DELEGATED DECISION TO DETERMINE PLANNING APPLICATIONS

Reference No:	2023/60/92734/W
Site Address:	adj, 15, Golcar Brow Road, Meltham, Holmfirth, HD9 5LD
Description:	Outline application for residential development
Recommending Officer:	Lucy Taylor

DECISION – CONDITIONAL OUTLINE PERMISSION

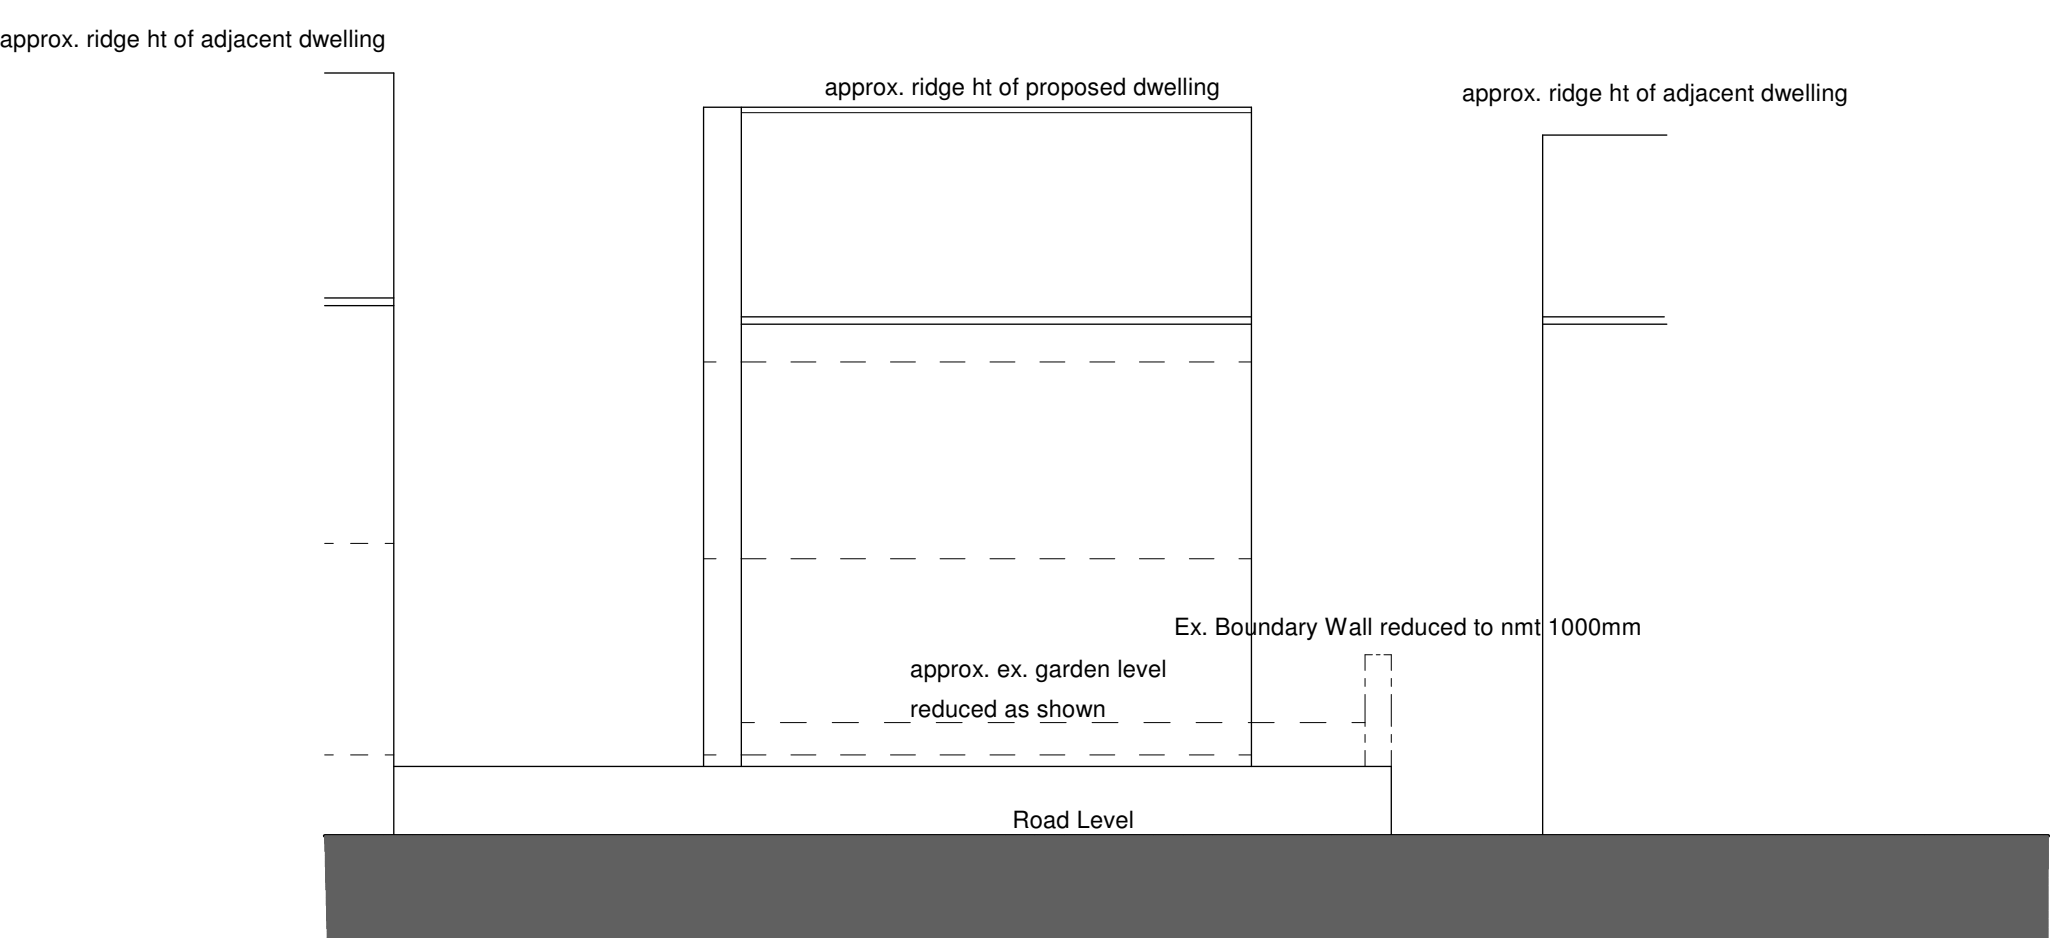
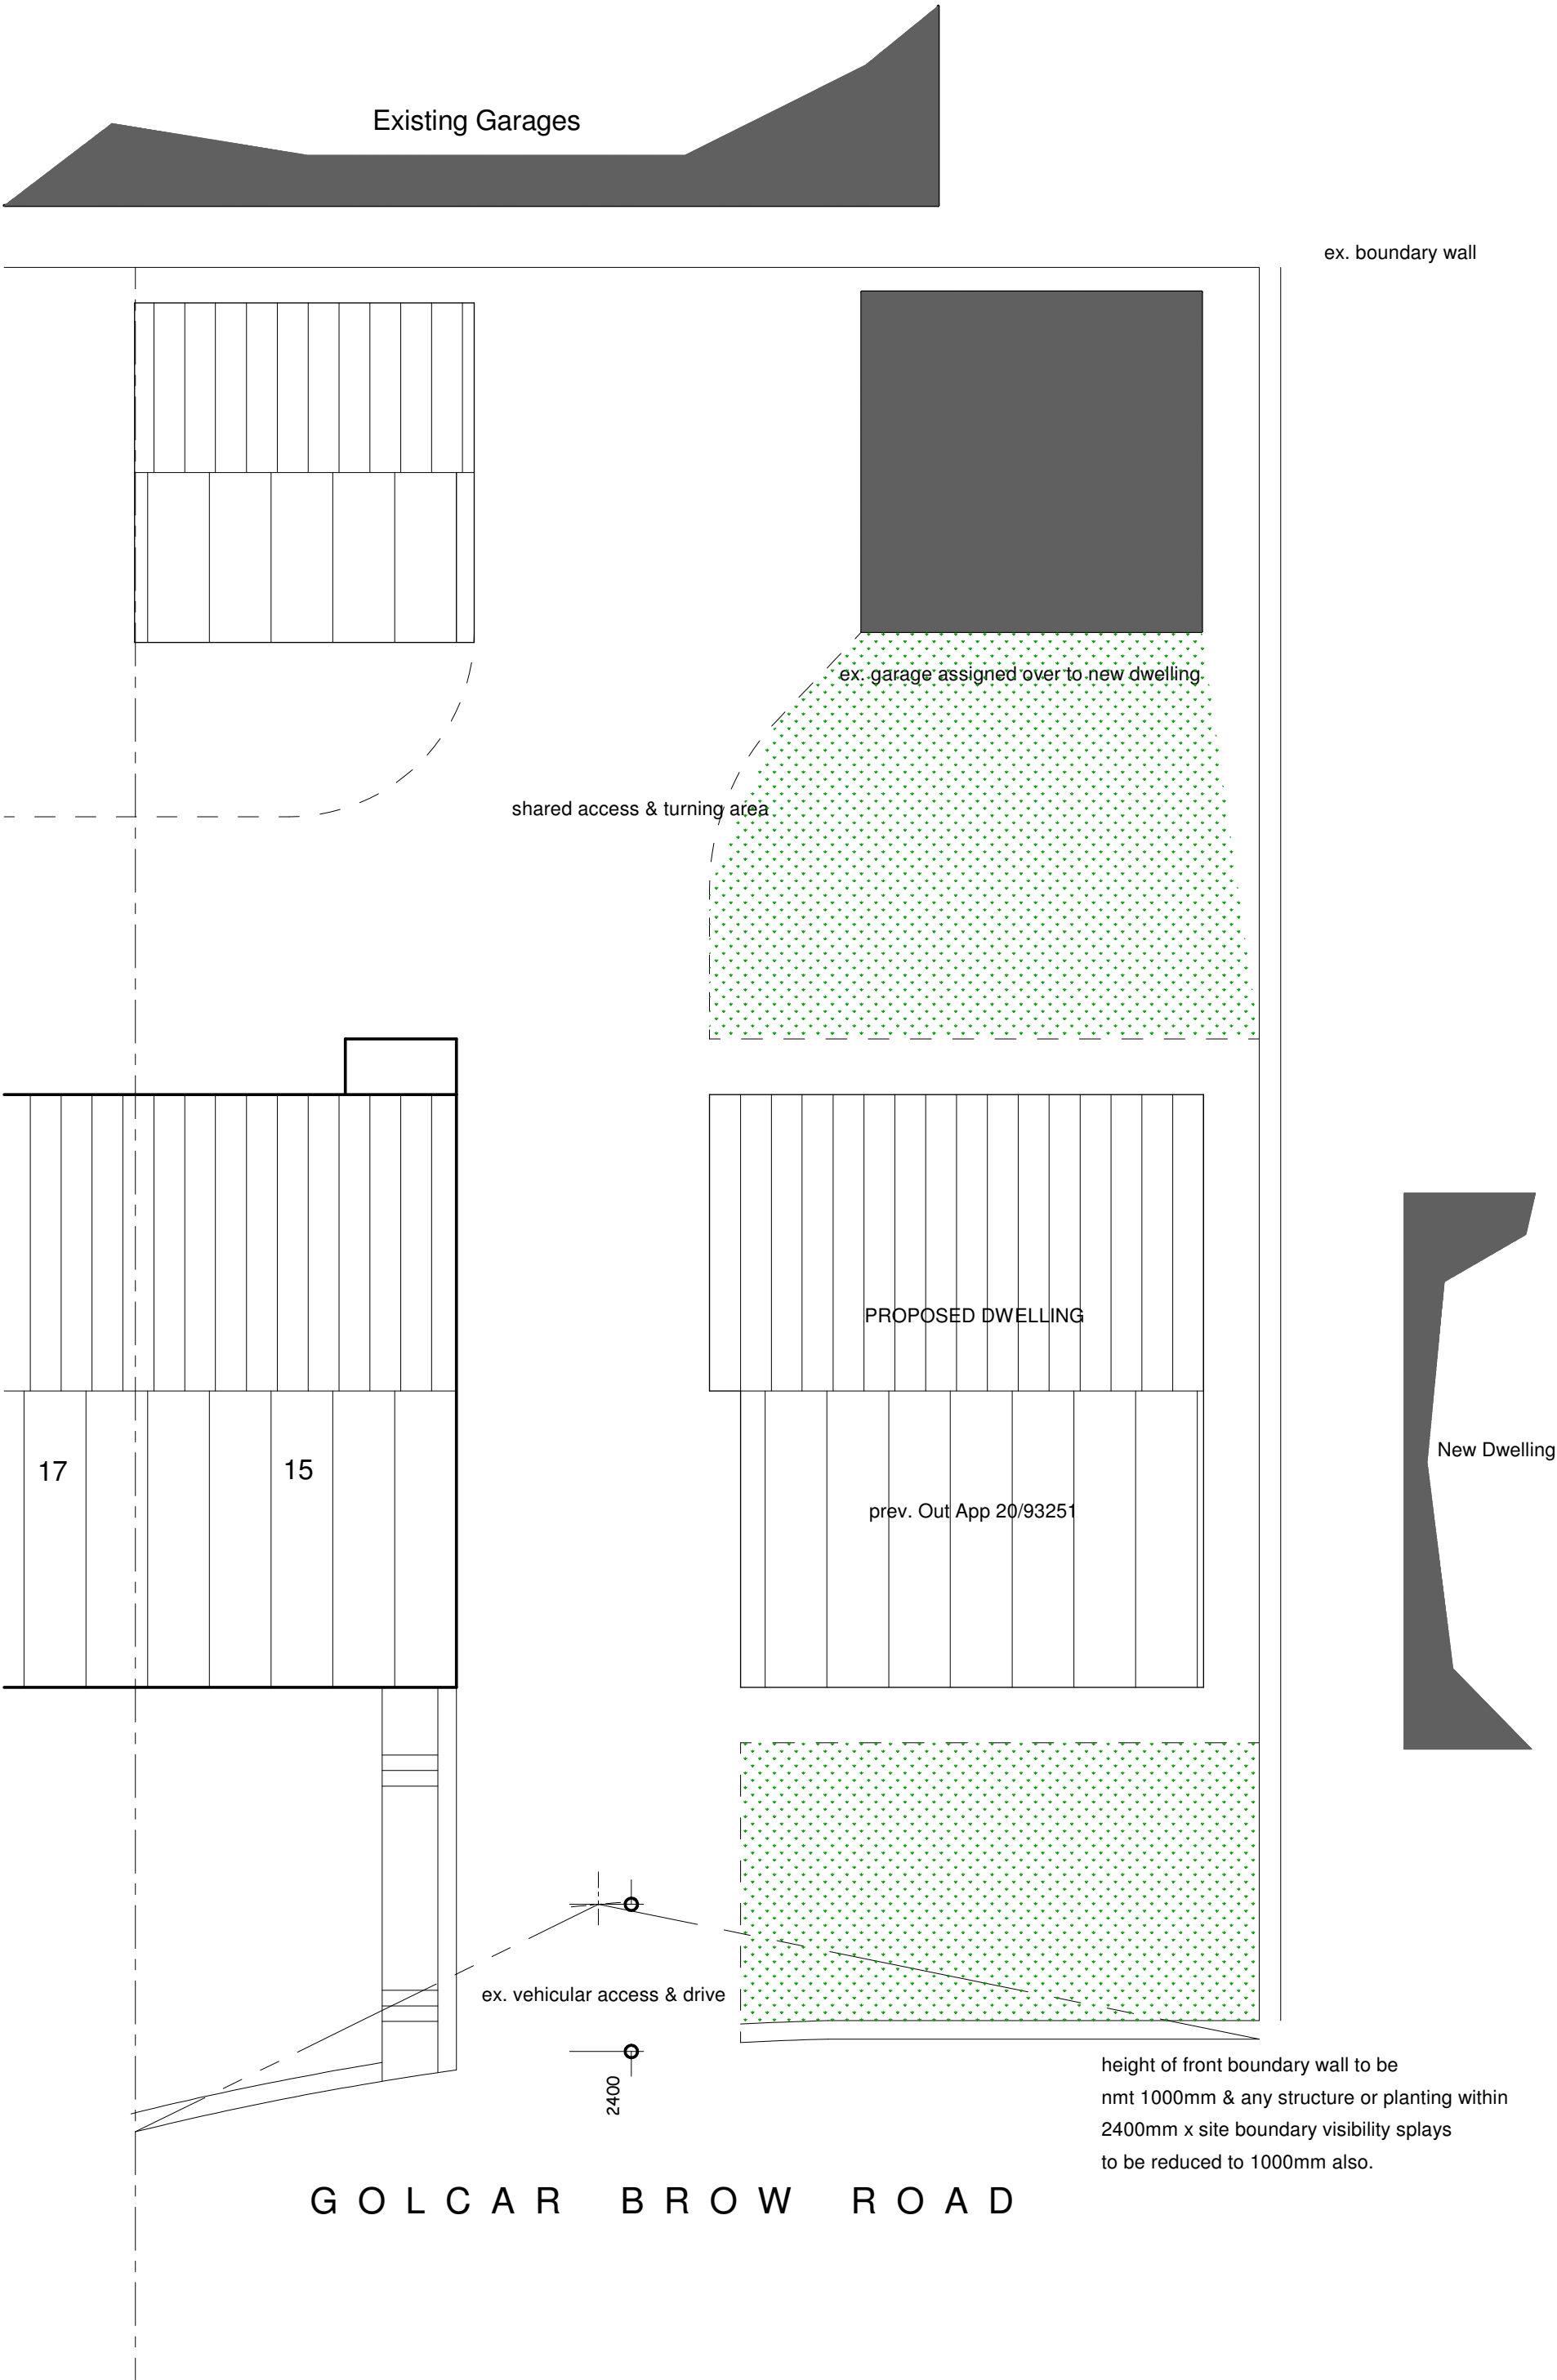
Although all matters are reserved, the proposal gives indicative details of the potential footprint, size and scale of the dwelling. The plans indicatively show the building to sit flush with the front elevation of No. 15 Golcar Brow Road and to sit slightly further back into the plot, compared to No. 11 Golcar Brow Road.

The indicative elevational plans show the dwelling to be two storeys high, and to not exceed the ridge roof line of No. 15 Golcar Brow Road.

Principle 5 of the Housebuilders Design Guide SPD states, amongst other things, that the buildings should be aligned and set-back to form a coherent building line and designed to front on to the street. In this case, an indicative plan has been submitted, which shows the dwelling to be in line with the neighbouring property of No. 15 Golcar Brow Road and to have a similar

footprint. The indicative plan also suggests that the proposed new dwelling would sit slightly further back into the plot, compared to No. 11 Golcar Brow Road.

Principle 15 of the Housebuilders Design Guide SPD sets out that the design of the roofline should relate well to the site context, including topography, views and heights of buildings and roof types. The application has been submitted with indicative elevations to show the new unit in relation to the street scene. This has indicated the overall potential bulk and massing, whereby a two-storey dwelling has been shown. This information is considered to be acceptable as it sufficiently demonstrates that a new building could be constructed within this location, that will retain the character and setting of the street scene.

The indicative plan submitted shows that an acceptable separation distance of approximately 22 metres can be retained from the nearest elevation of No. 2 Badger Brow. This separation distance would ensure that any potential overbearing, overshadowing, and overlooking would not have an undue impact upon these neighbour's amenity.

Officer's note that the new proposed dwelling would retain a separation distance of approximately 0.9 metres from the shared boundary with No. 11 Golcar Brow Road and a separation distance of approximately 3.4 metres from the siting of this neighbouring dwellinghouse itself.

Officer's note that the new proposed dwelling would retain a separation distance of approximately 4 metres from the nearest elevation of 15 Golcar Brow Road (eastern facing side elevation). Officers have considered that this property does benefit from two openings in its eastern facing elevation, however, given the size, scale and siting of these windows, it is considered that they appear to be secondary windows or to serve non-habitable rooms internally.

In the instance of previous application 2020/9321, Highways Officers raised concerns, as a fourth bedroom was demonstrated to be created within the roof space. The submitted Design Statement for this application states that the new dwelling would have four bedrooms. Given the number of bedrooms proposed, it would be recommended that a three off street parking spaces be clearly shown on plan for the new dwelling.

Alongside this, the photo of the existing garage within the Design Statement suggests that it is a single garage, with access to the front and not to the side. As recommended by Highways Officer's under previous application 2020/93251, it would again be suggested that upon any subsequent submission of a reserved matters application, plans clarify the parking arrangements on site and be dimensioned to allow the proposals to be assessed properly.

6. The details submitted in respect of landscaping pursuant to Conditions 1 and 2 shall be accompanied by a scheme of details for off street parking for both the new dwelling and no. 15 Golcar Brow Road which allows for manoeuvring within the site.
